from
**Southern
Water**

Our ref
PLAN-034392

Proposal: Approval of details reserved by condition imposed under ref A/51/14/OUT relating to Condition Nos 19 - foul water sewerage disposal and 20 - public water supply main.

Site: A/86/20/DOC: - Manor Nursery, High Street, Angmering, BN16 4AW.

CLIENT	Roffey Homes Ltd		
PROJECT	Manor Nurseries Site Angmering		
TITLE	Proposed Drainage Strategy		
DRAWN	DATE	PROJECT NO.	
T Zajac	Mar 2018	22995	
ENGINEER	CHECKED	DWG NO.	REV.
S Magowan		102	B
SCALE	1:250 @ A1

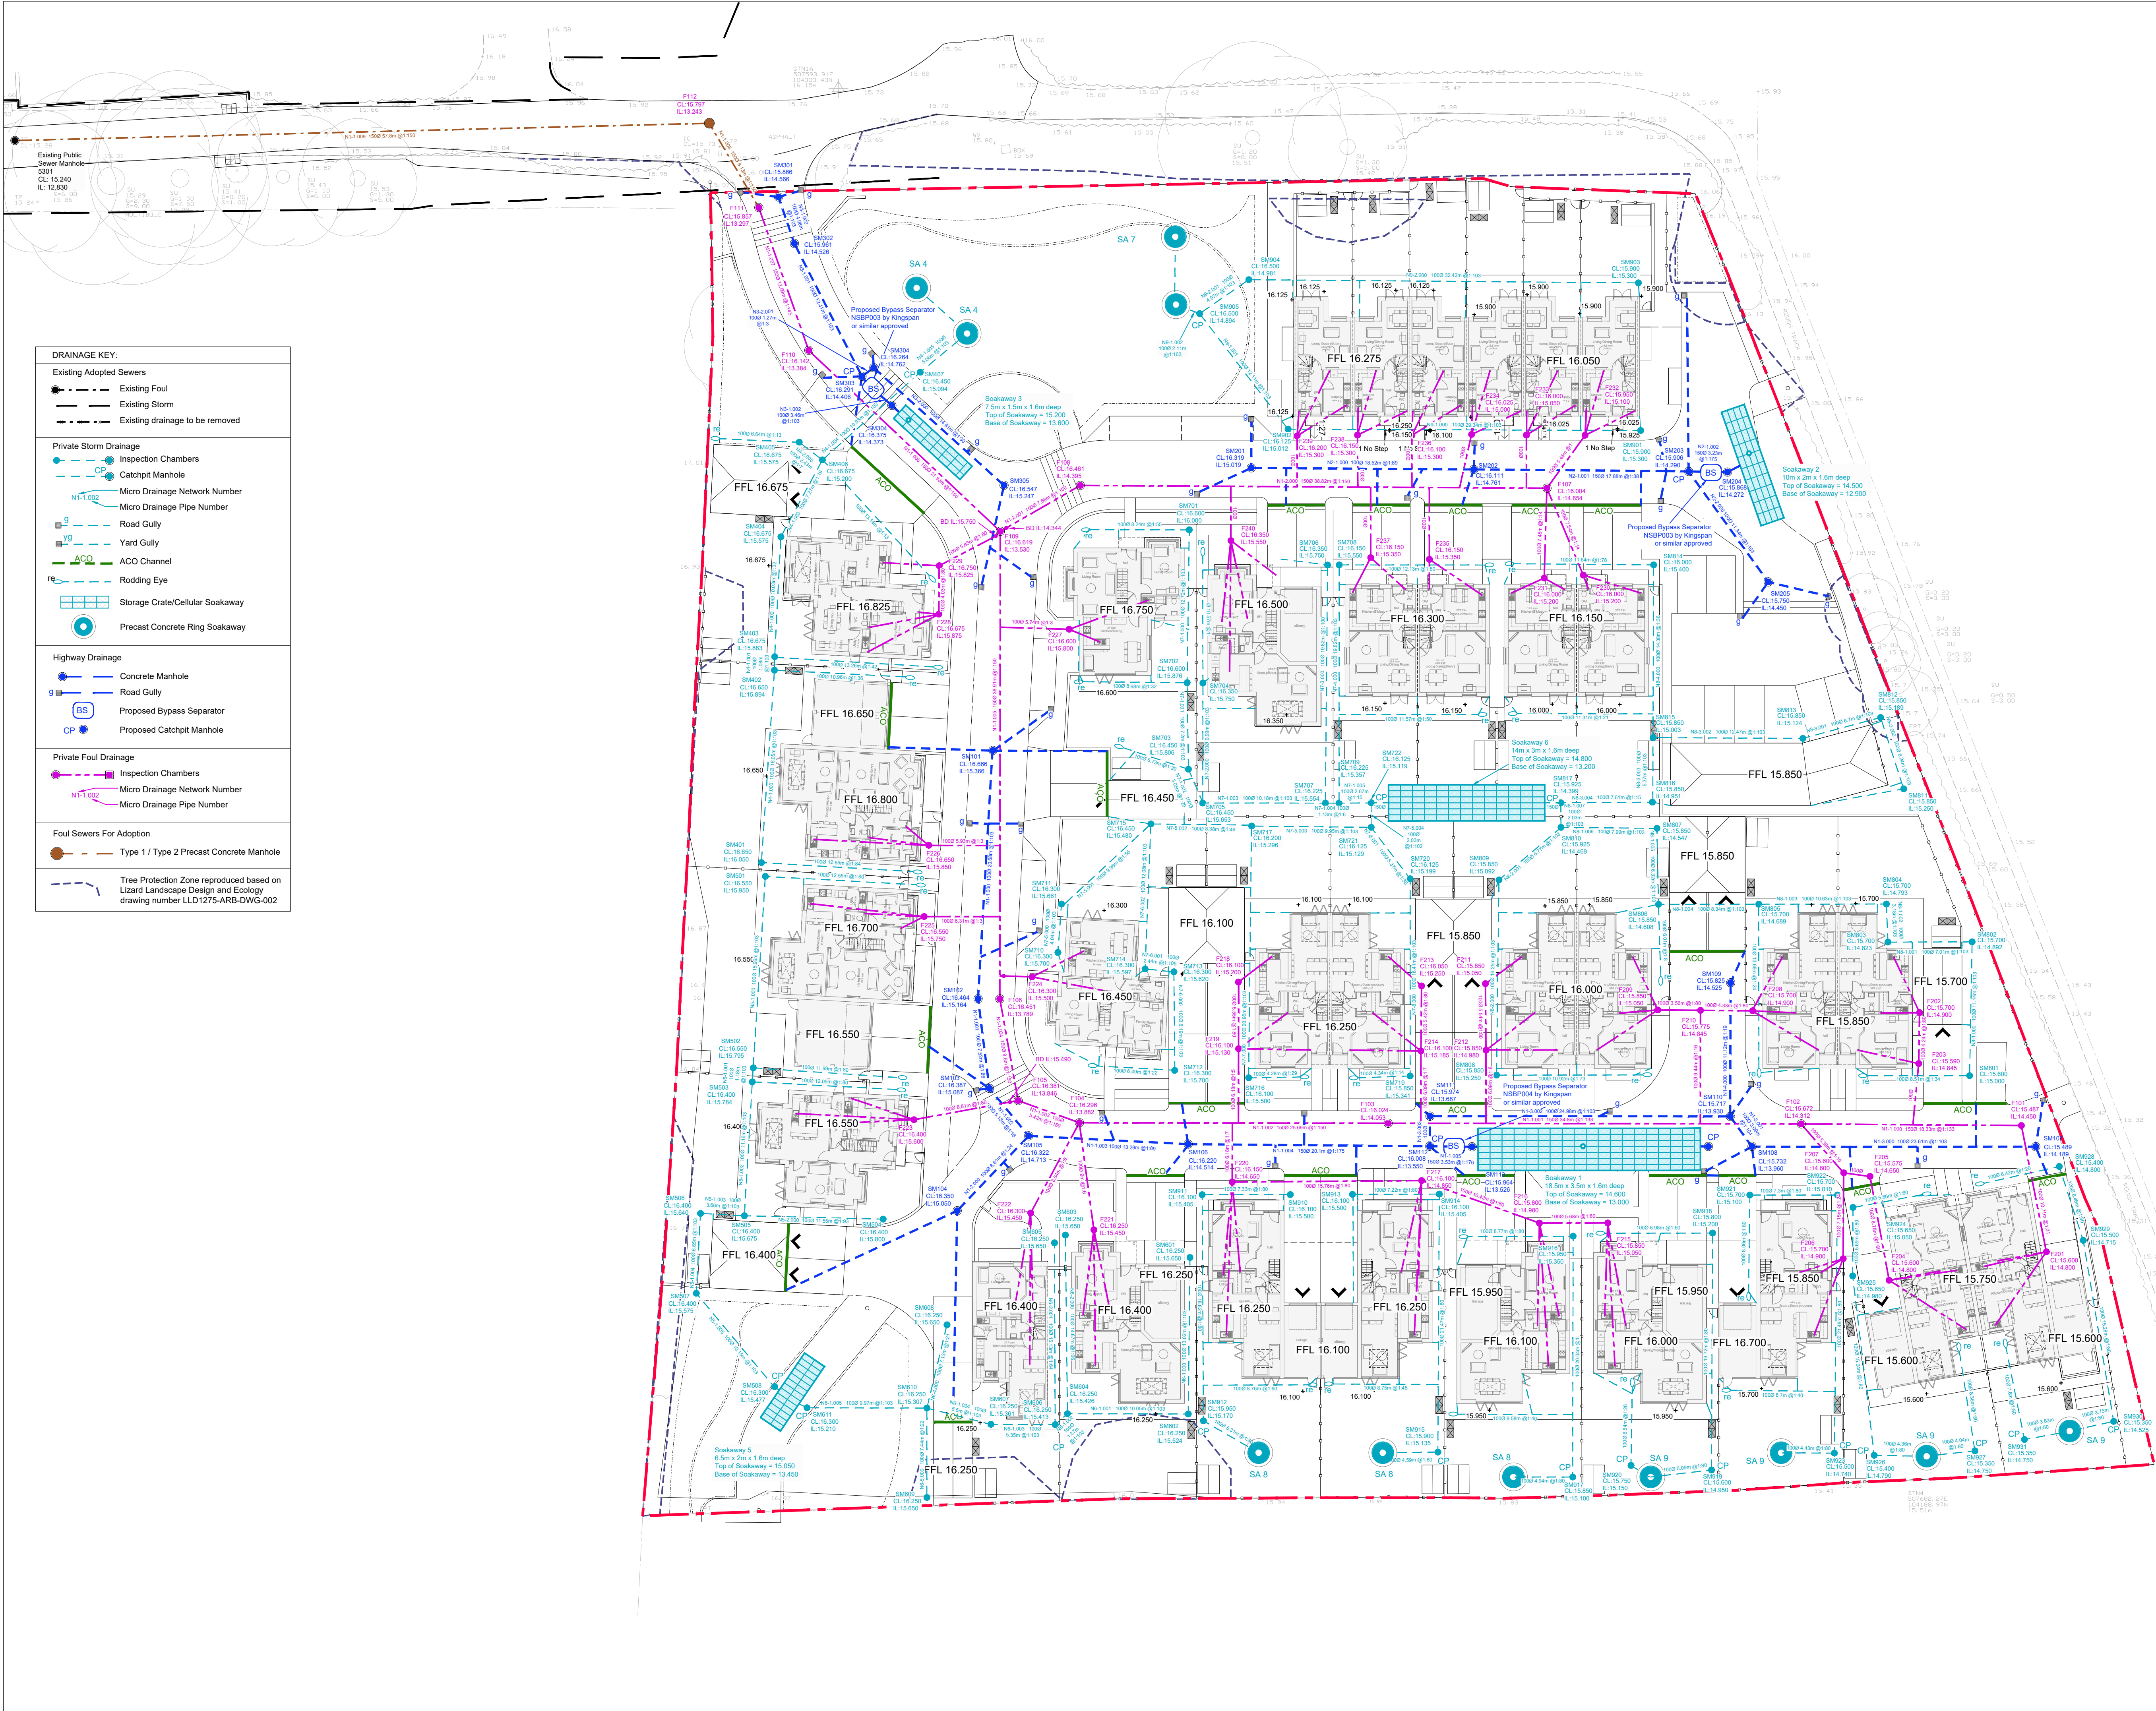
Southern Water cannot recommend discharge of condition 20 relating to protection of public water supply main. The submitted plans do not show any protection measures (easement) for the water mains.

Also, the proposed soakaways are located within the standoff distance of public water main.

A realignment will be needed to the soakaway position to create a greater clearance between the soakaway and public water main.

No soakaways, swales, ponds, watercourses or any other surface water retaining or conveying features should be located within 5 metres of public water main.

No development, excavation, mounding or tree planting should be carried out within 6 metres of the external edge of the public water main without consent from Southern Water.

The drainage proposals shall include protection measures to be shown to satisfy the requirement to maintain standoff distances for public water mains.
